**Sub: Submission of documents mentioned in Tamilnadu Housing and Urban Development Department Letter (Ms.) No.61, dated 24.05.2018- CMDA PPA File no: C3 (N)/10508/2017-Regarding**

Sub: CMDA – Area Plans Unit – MSB (North) Division – Planning Permission Application submitted for the proposed construction of Ground floor (part) / Stilt floor (part) + 6 Floors, Comprising 57 rooms of lodging accommodation (for staff) at No 45, Kothari Road, R.S.No 567/28, Block No.33 of Nungambakkam Village, Egmore Taluk, Chennai – 600034, Ward No 110, Zone 9 of Greater Chennai Corporation - under premium FSI category– Remittance of DC & Other Charges - Advise sent - Reg.

DRAWING TITLE: RESIDENTIAL STAFF ACCOMMODATION FLOOR PLANS
SCALE: 1:100 DRAWN: REKHA
DATE: 04.02.14 CHKD: SA
DRAWING NO: 07H07HARI-11041
For INFOSYS LIMITED

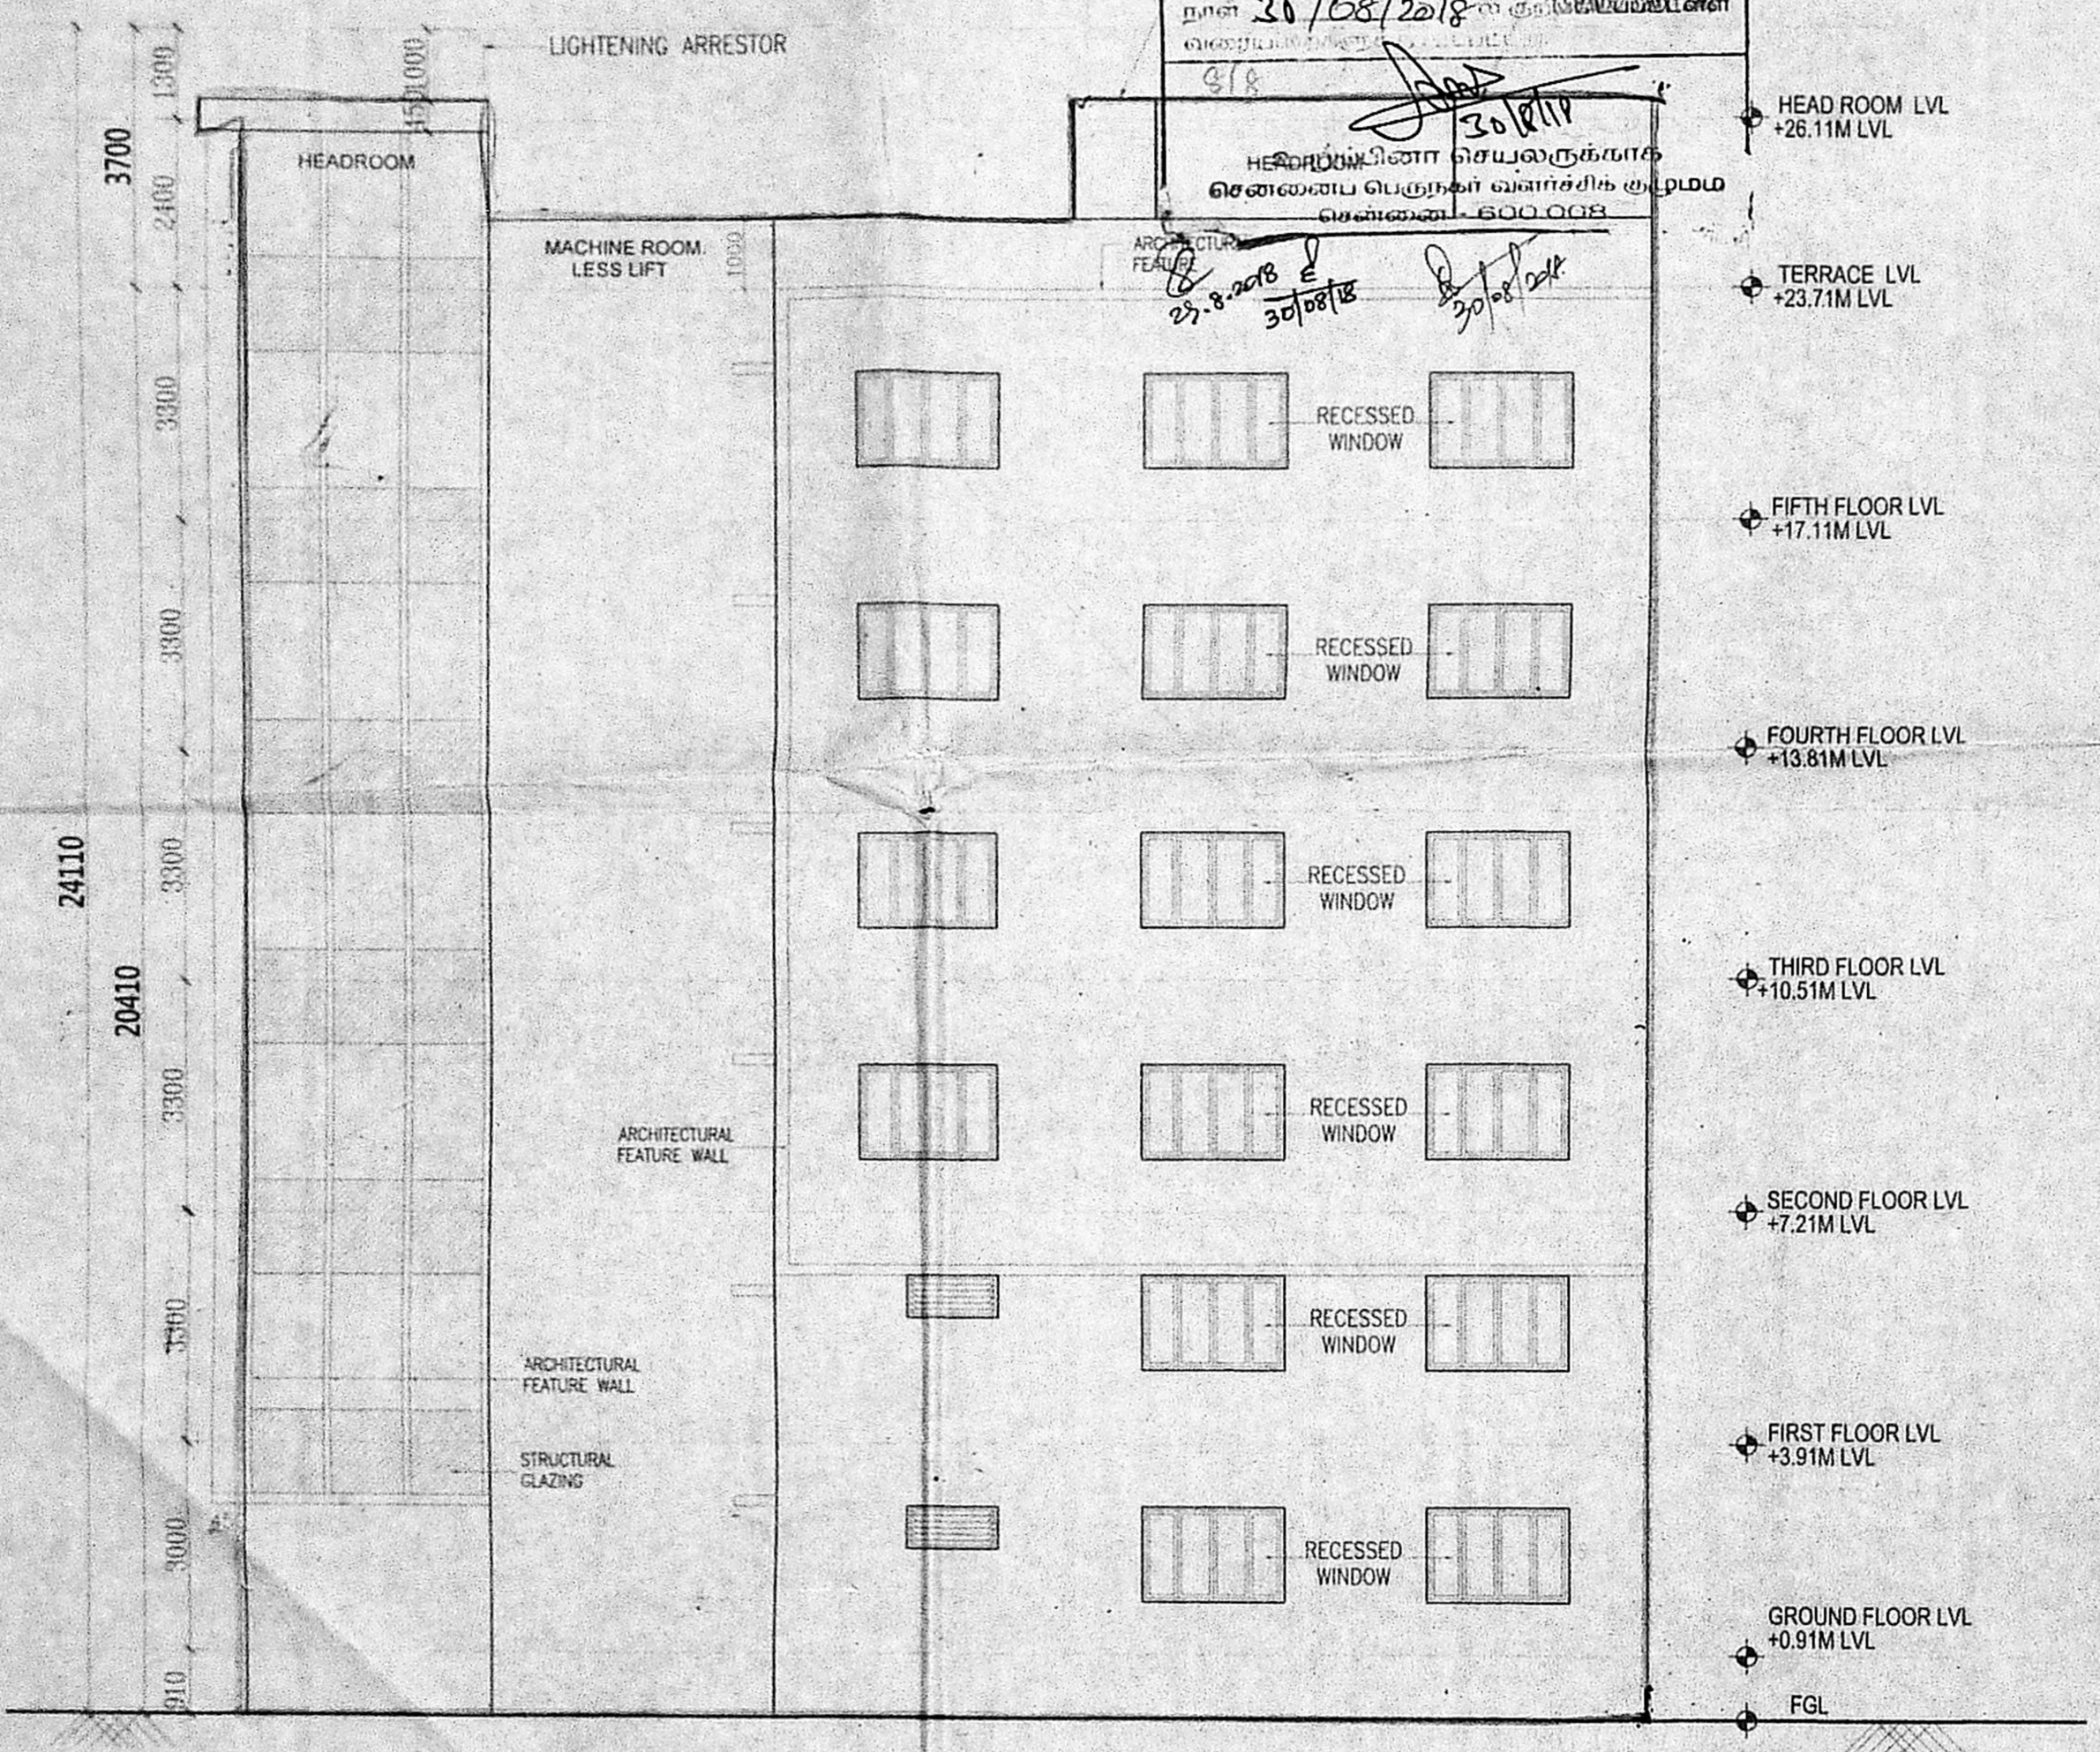
- iv. The site is not covered under Land Acquisition.
- vii) Revised plan rectifying the following drafting corrections
  - a) PHC provision to be provided.

- c) Setback from least boundary to be shown.
- d) Outer dimension to be mentioned in the typical floor plan.
- e) Area statement to be corrected.
- f) Fire escape staircase to be mentioned.
- g) Staircase headroom to be mentioned in the terrace floor plan.
- h) STP to be shown in the site plan.
